Pitt Street South Over Station Development Stage 2 (SSD-10376) - Notice of Exhibition

Thank you for your correspondence via the Major Projects Portal on 28 May 2020, requesting Transport for NSW (TfNSW) to review and comment on the above.

Figure 3-1: Vehicle swept path analysis for the SRV western bay – reverse in and forward out from bay

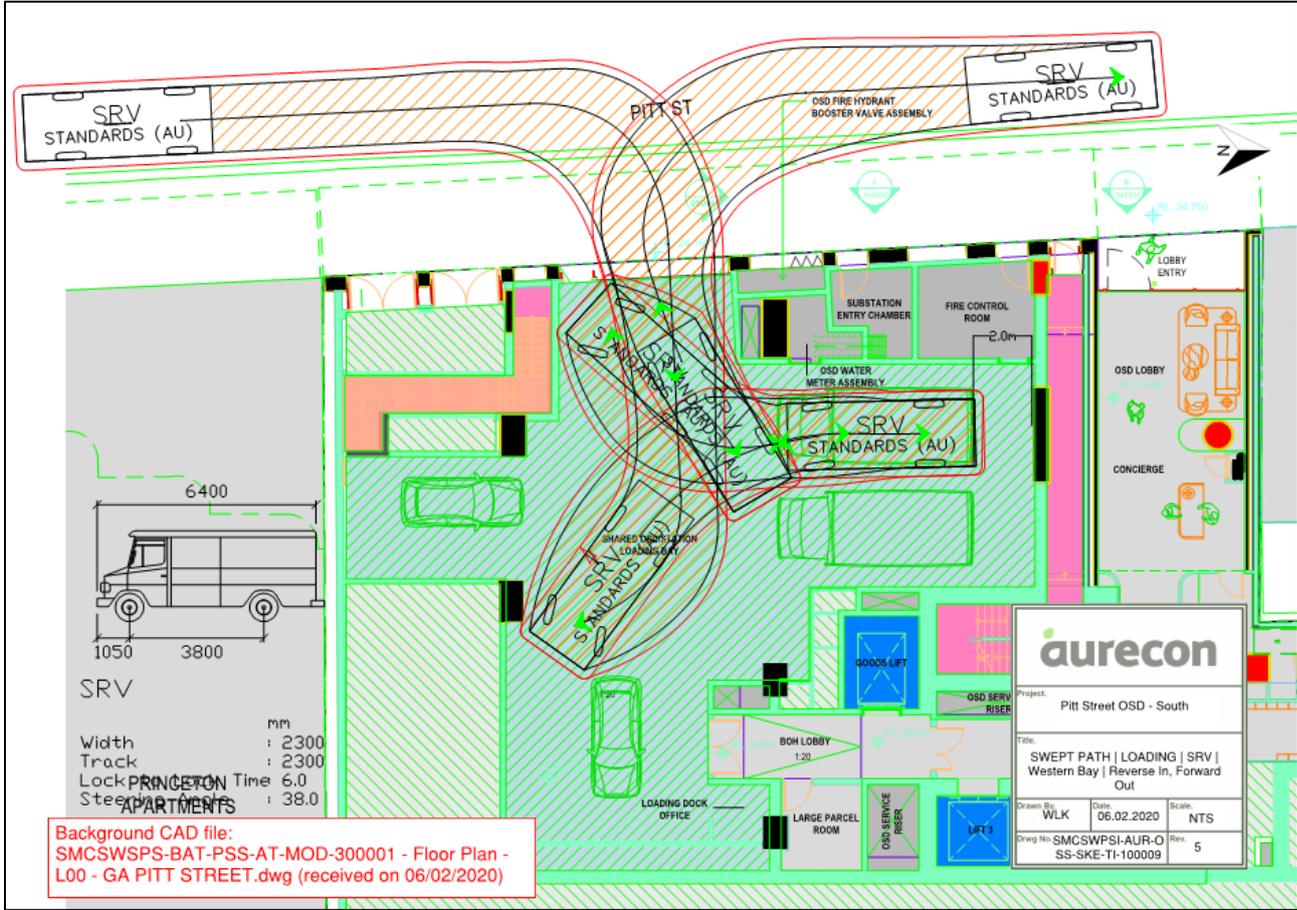
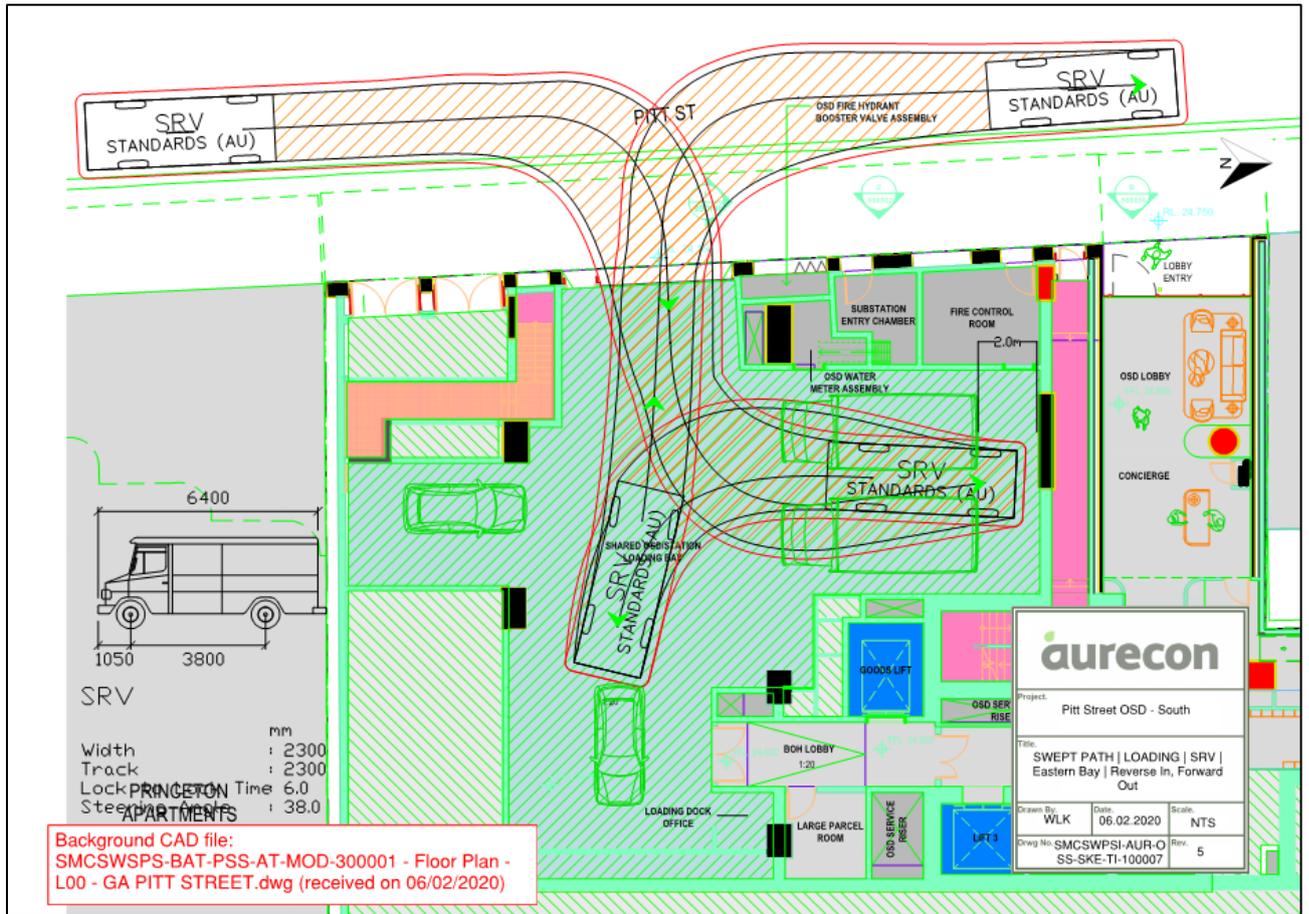
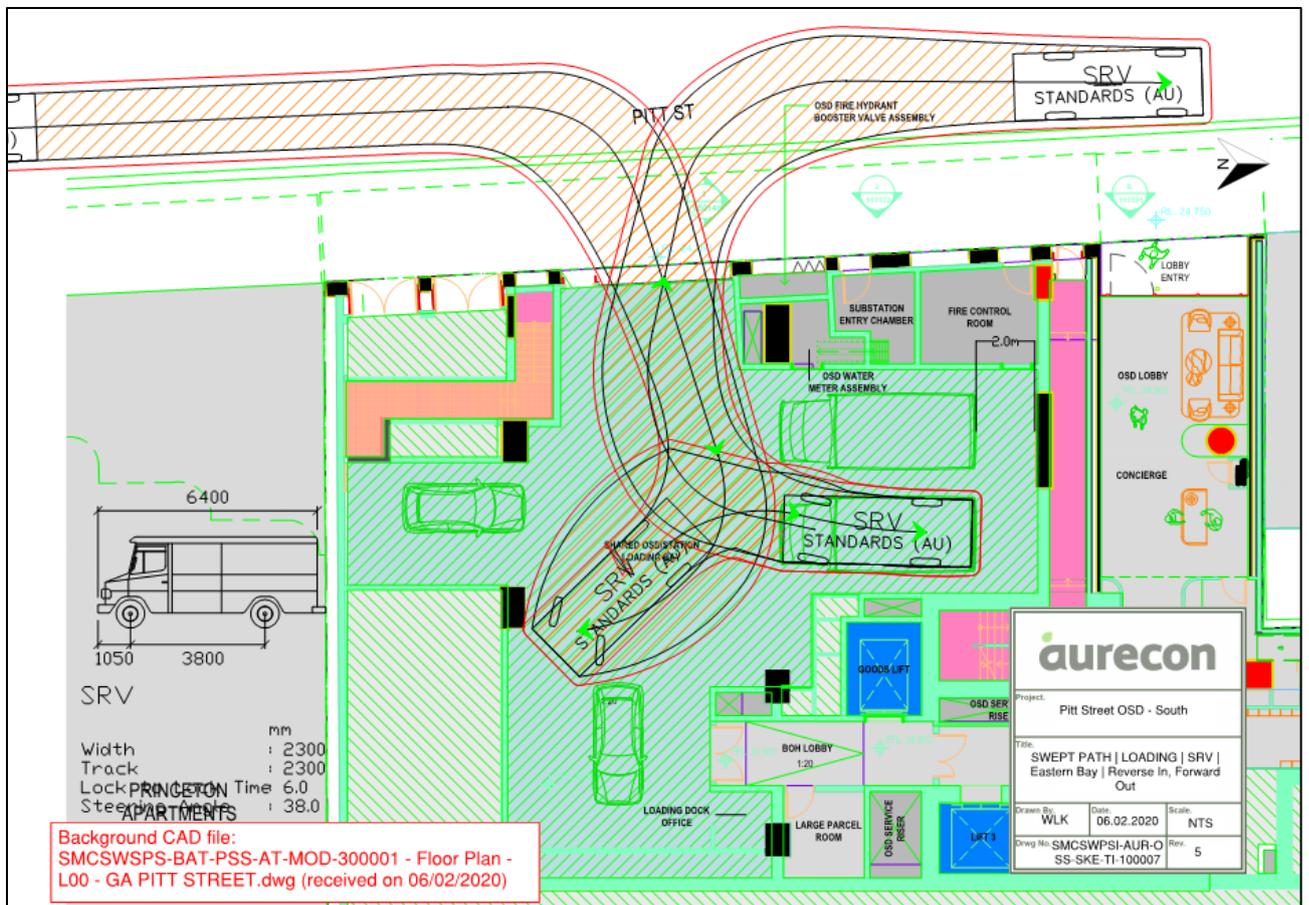
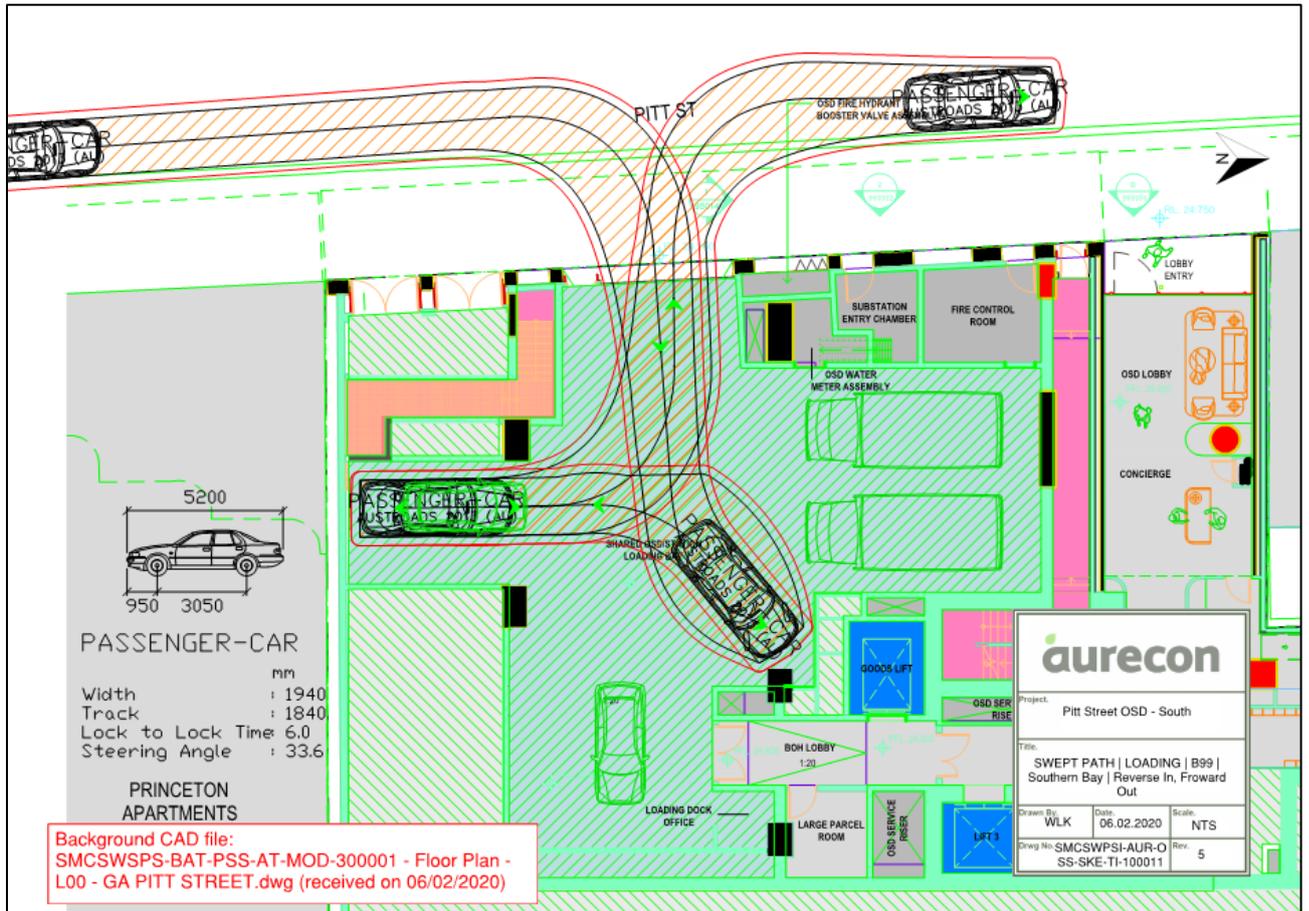
- Service vehicle movements (reverse into or out of loading bays) within the loading dock would cause safety issues for cyclists and pedestrians accessing the loading dock area;
- Given that the location of two convex mirrors is beyond the property boundary, a separate application should be made for approval of TfNSW for these mirrors;
- Any loading zone outside the station entrance on Bathurst Street is not supported; and
- All new developments should not rely on on-street parking or loading zones. Kerb side restrictions can be changed at any time and the development should not rely on current kerb side restrictions to service the site.

It is requested that the applicant be conditioned to prepare a Loading and Servicing Plan in consultation with the Sydney Coordination Office within TfNSW by updating the Service Delivery Plan, prior to the issue of any Construction Certificate.

Figure 4-17: Bike parking access proposed via the loading dock

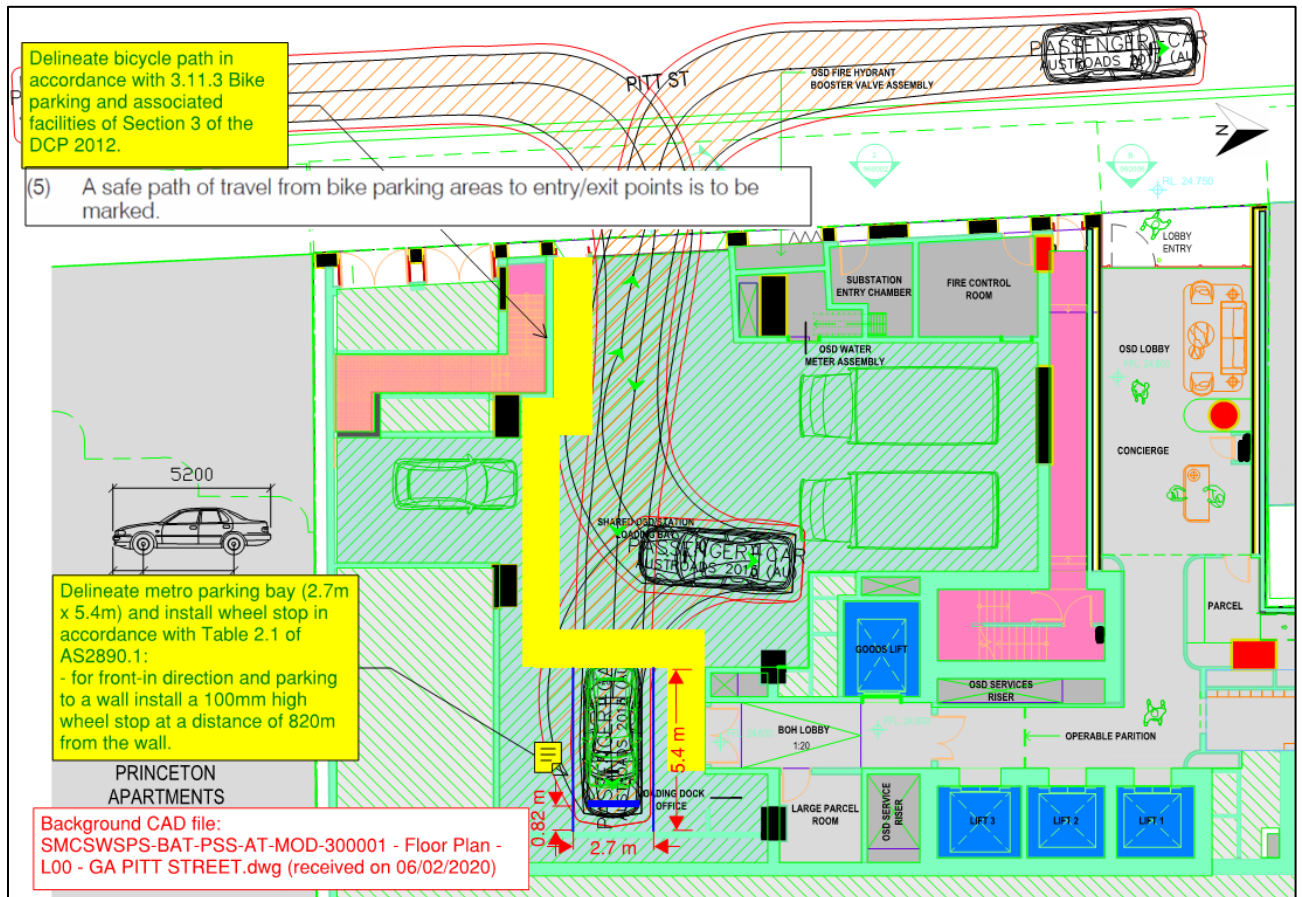
- Proposed bicycle parking access via loading dock would have the potential to cause safety incidents between cyclists and service vehicles;
- In relation to bicycle parking spaces on Bathurst Street, City of Sydney needs to approve the parking spaces and the applicant needs to consult with Edinburgh Castle as these parking spaces would be located adjacent to the Edinburgh Castle
- No bicycle parking spaces are proposed for bicycle couriers for the above development; and
- No detailed information is provided in relation to end of trip facilities. Staff of the retail and restaurant areas making use of active transport will require end of trip facilities in a location convenient to their place of work.

- Locates resident and visitor bicycle facilities in secure, convenient, accessible areas close to the main entries, incorporating adequate lighting and passive surveillance and in accordance with Austroads guidelines;
- Considers to provide bicycle parking arrangements for bicycle couriers;
- Designs bicycle parking spaces to locate on Bathurst Street such that adequate footpath width is provided for pedestrian movements; and
- Provides adequate end of trip facilities for the development.
